# TRANSPORT FOR LONDON

## M25 JUNCTION 28 IMPROVEMENTS – DEADLINE 8 SUBMISSION

9 JUNE 2021

TRAFFIC MANAGEMENT LAYOUT 1
A12 EASTBOUND LANE 1 CLOSURE
IN ADVANCE OF EXIT SLIP

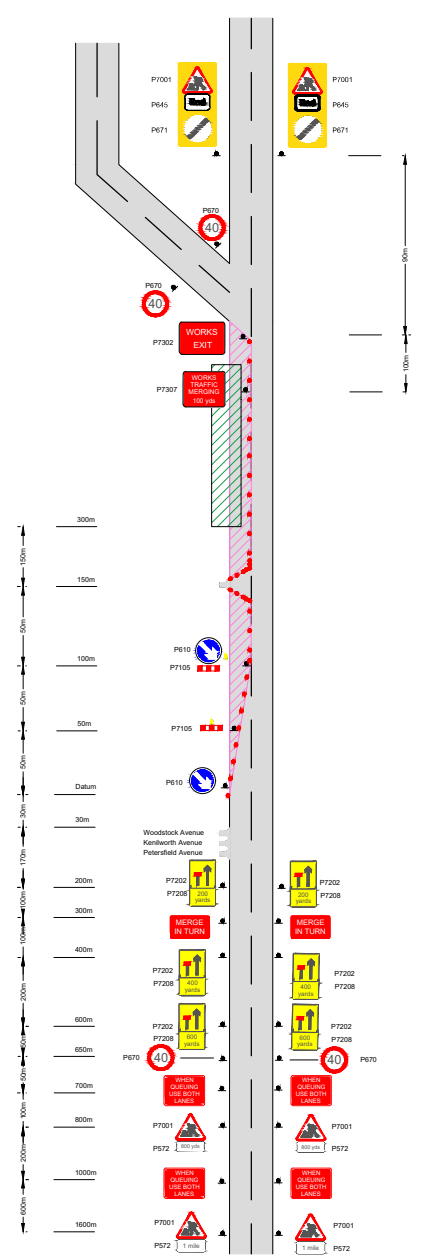
5.1.3 However, a third change does cause concern. The previous version of the outline TMP included closure of Lane 1 on the eastbound A12 for tie-in works for the new slip road for up to 20 nights. The updated outline TMP states that a closure of Lane 1 will be required for a total of up to 35 days. TfL requires more information to specify whether these are all weekend days or if any lane closures are planned on weekdays at peak times. TfL previously raised concerns about whether off peak lane closures of the A12 were modelled in the Transport Assessment Supplementary Information Report (TASIR) (PDB-003), with the Applicant confirming these off peak closures have been modelled (REP6-011 section 2 table row TA 2.4 paragraphs 4.2 and 4.3). If lane closures during weekday peak periods were required, this would potentially cause significant congestion issues due to the higher traffic levels during these periods, with peak period closures presumably having not been modelled in the TASIR. Further clarification is required to provide information on the impacts of the scheme on traffic.
